REQUEST

Current Zoning: N1-A (neighborhood 1-A)
Proposed Zoning: R-17MF(CD) (multi-family residential, conditional)

Approximately 4.37 acres located on the north side David Cox Road, east of West Sugar Creek Road, and south of Hayden Drive.

The petition proposes development of up to 43 single-family attached townhome residential dwelling units on a site with one existing single-family dwelling.

DRAWING NUMBER:
RZ-1

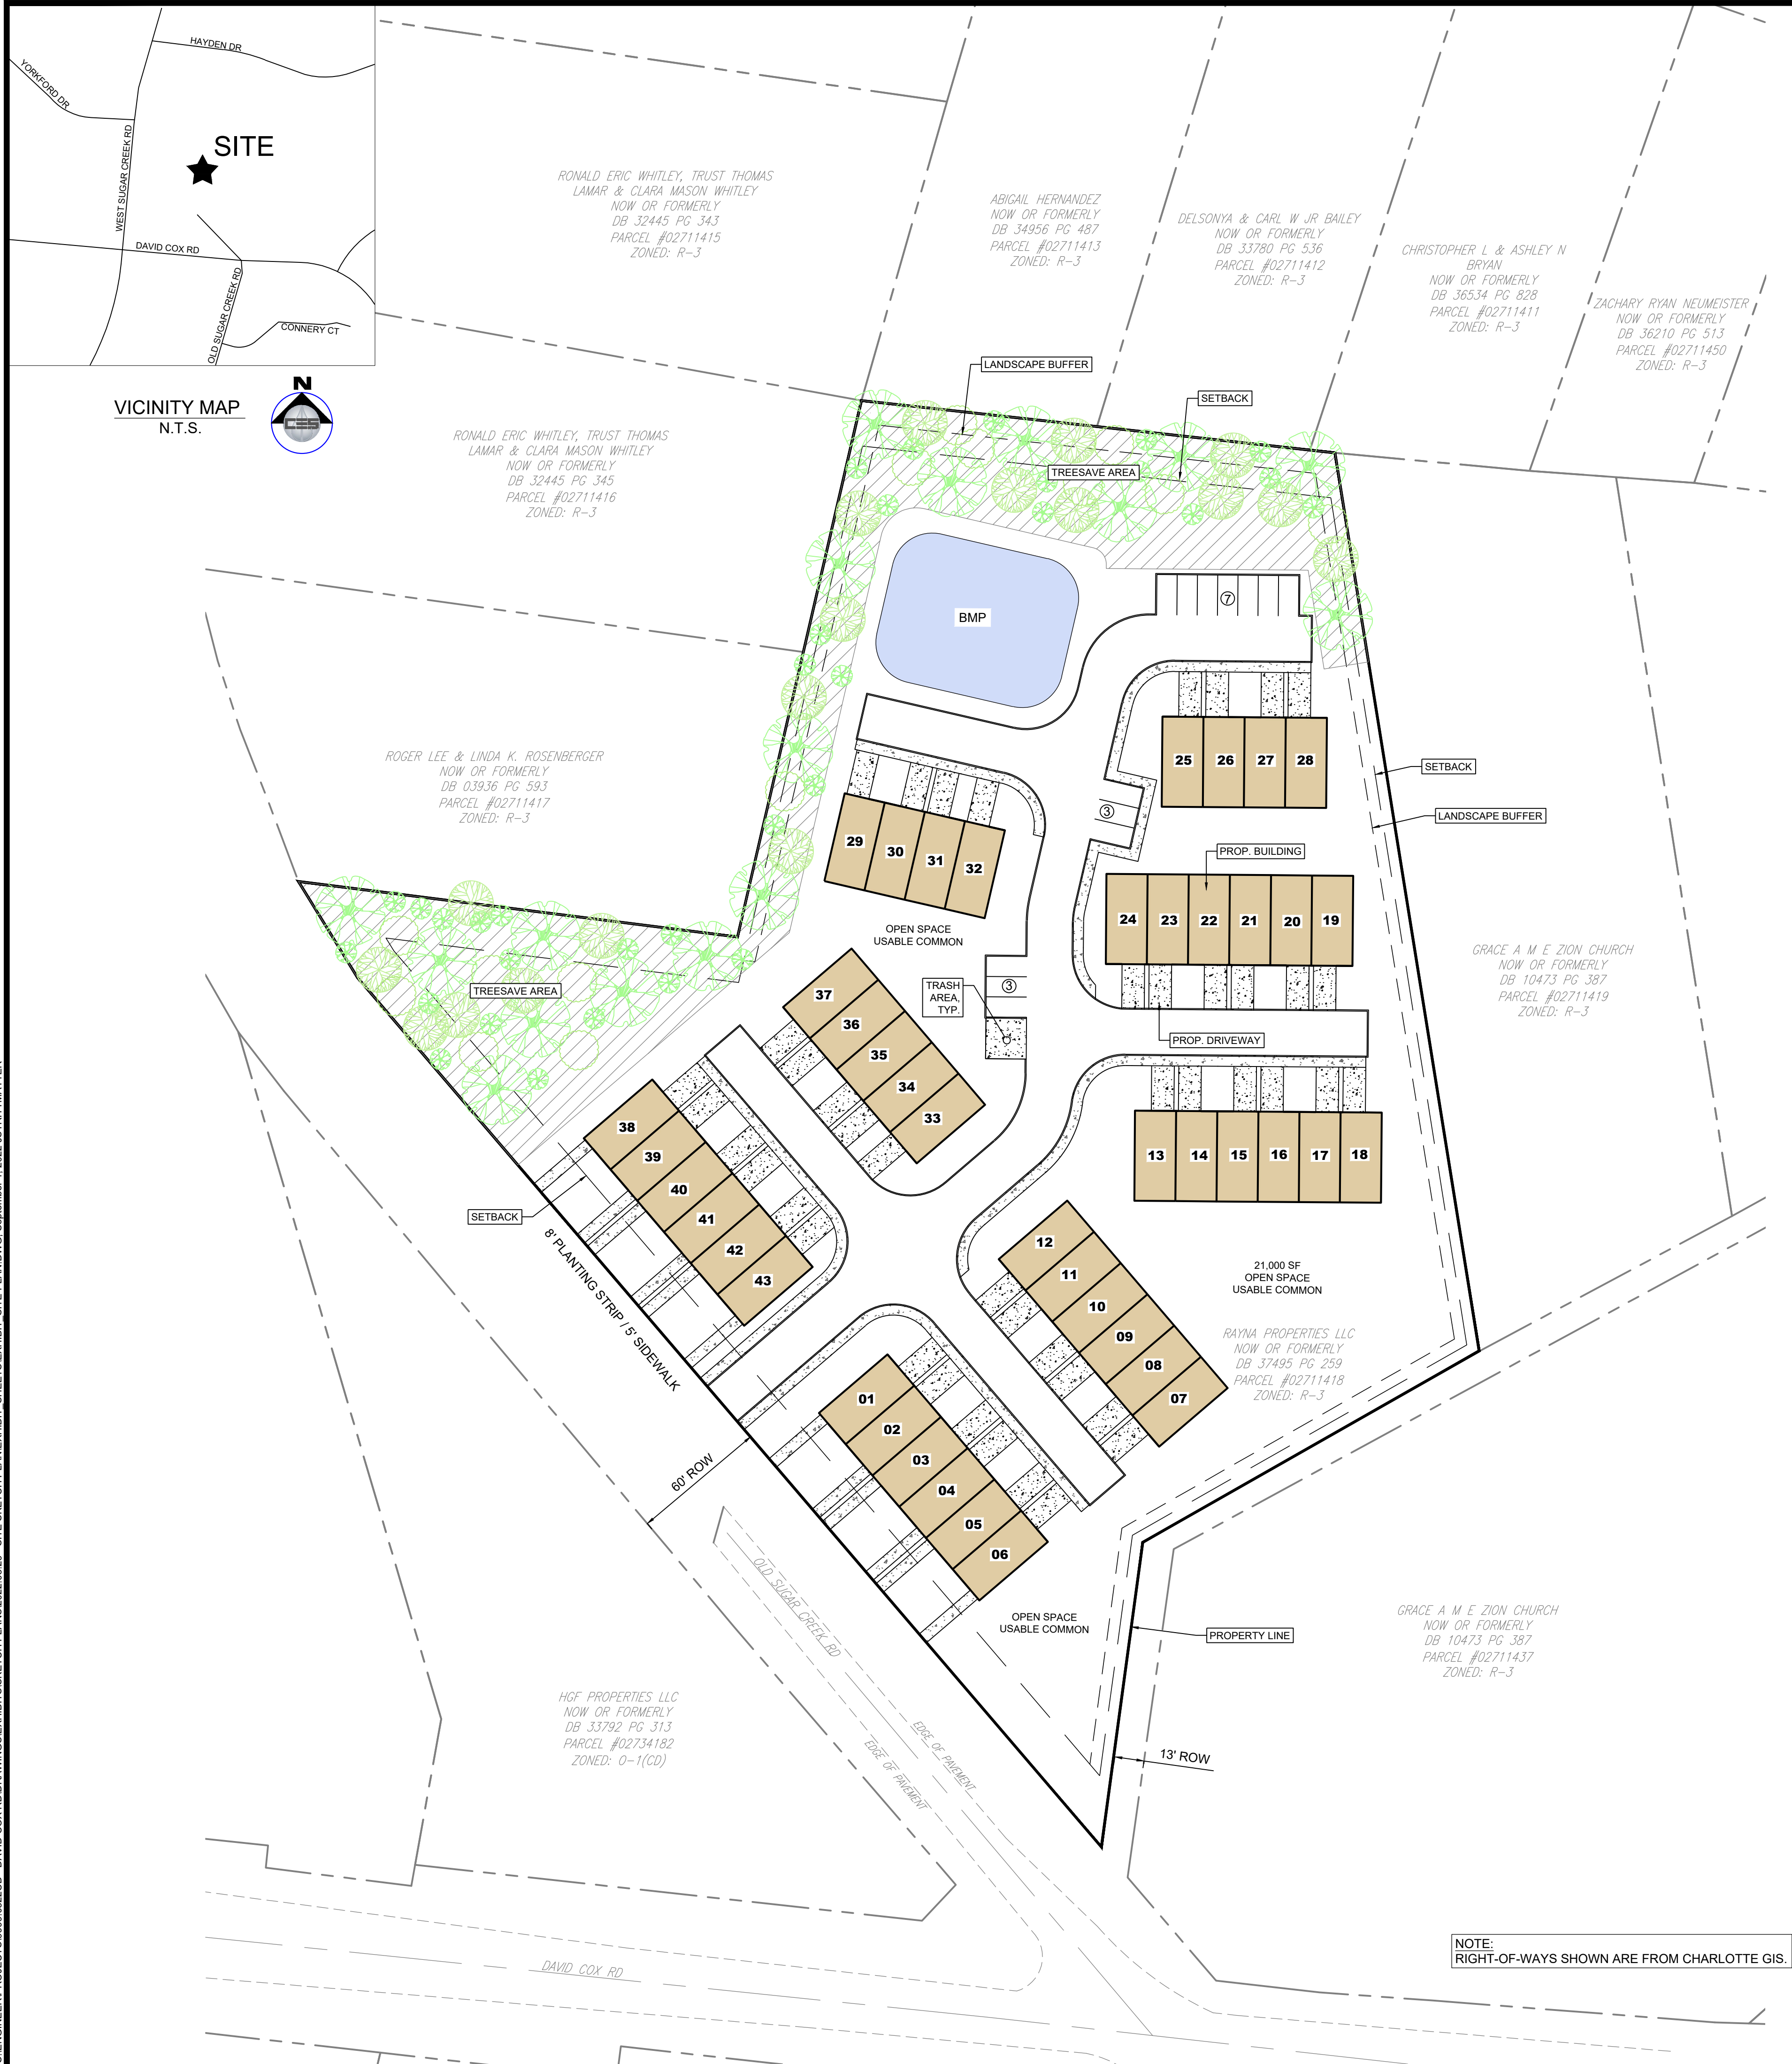
1. Revise conditional notes by modifying the conditional notes to reference the proposed roadway in lieu of Old Sugar Creek conditional notes as Old sugar creek is to be abandoned (see above comments regarding abandonment). Conditional notes are to reference the proposed roadway and not Old Sugar Creek.
2. Revise site plan to remove extension of private streets to property line.

3. Revise site plan to better align proposed use with Neighborhood 1 Place Type.
